REF: N174701

DATE: 20 December 2021

### RE: NEW LIVERPOOL PRIMARY SCHOOL SSD-10391 RESPONSE TO TRANSPORT RELATED SUBMISSIONS

Table 1: DPIE Comments and Responses

Drawing Title
SITE PLAN - PART 2

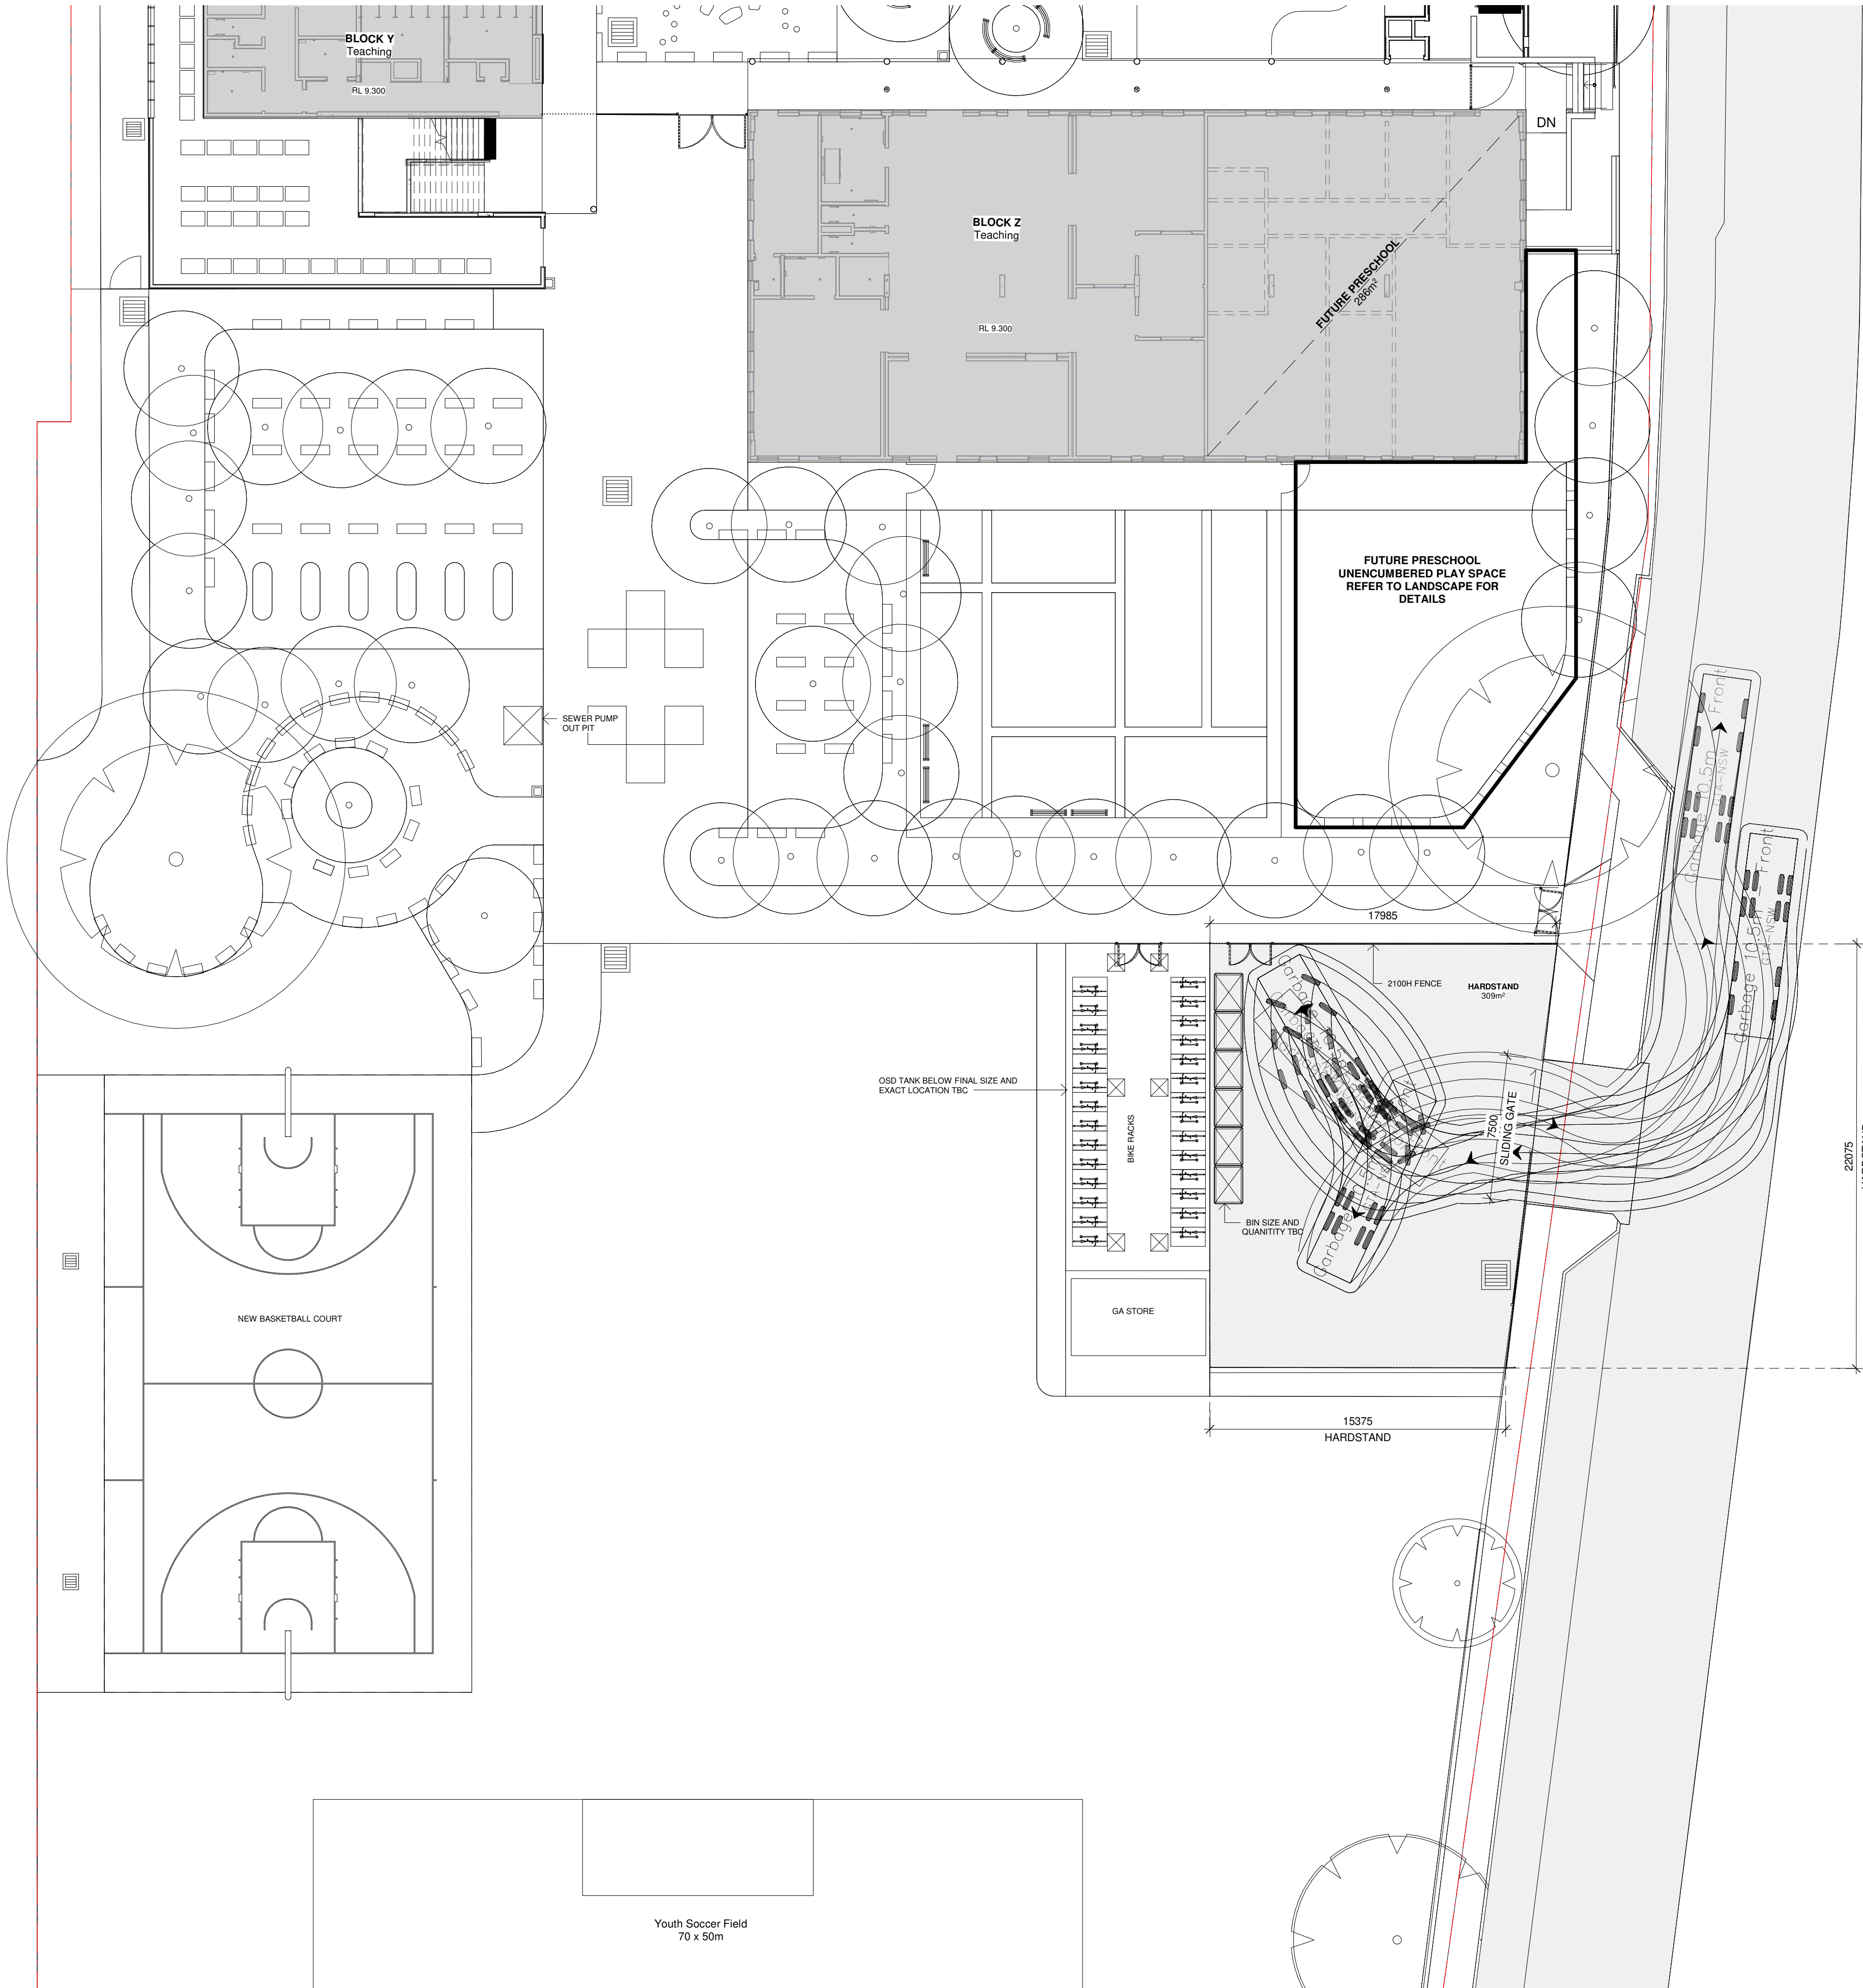
<p>the current bike parking location results in bikes being transported through the courtyard or the hardstand gate. The bike parking should be relocated closer to the student entry and away from the waste area to encourage a modal shift in the future.</p>	<p>Review of entry locations has been undertaken, including considering moving bike parking closer to student entry location. However, there are conflicting other services required in these locations that prevent this outcome further. SINSW prefer the bike</p>

Comment	Responses
	storage area to be located further away from the courtyard. It is noted that the waste hardstand area will be fenced and separated from the bike parking area.
<p>It is noted that the proposed roundabout at the southern end of Burnside Drive forms part of a separate application.</p> <p>However, further information is required regarding the relationship between the primary school staff car park and the roundabout. The details of the vehicles using the roundabout, should also be provided.</p>	<p>The new roundabout is proposed to facilitate turnaround for vehicles originating from the north of Burnside Drive to access the pickup and drop off bays located on the western side of Burnside Drive. Access to the staff car park will be via a left in/ left out arrangement with vehicles originating from the north using the roundabout to access the staff car park driveway.</p>
<p>Please confirm whether Burnside Drive is wide enough to allow for bus access or whether an alternative access is proposed.</p>	<p>Bus access is not proposed from Burnside Drive. A bus zone is proposed on Lachlan Street north of the existing Liverpool Boys High School. A swept path assessment has been undertaken that demonstrates buses can turn around at the existing Hart Street/ Lachlan Street roundabout to access the southern side of Lachlan Street. Refer to Attachment 2.</p>
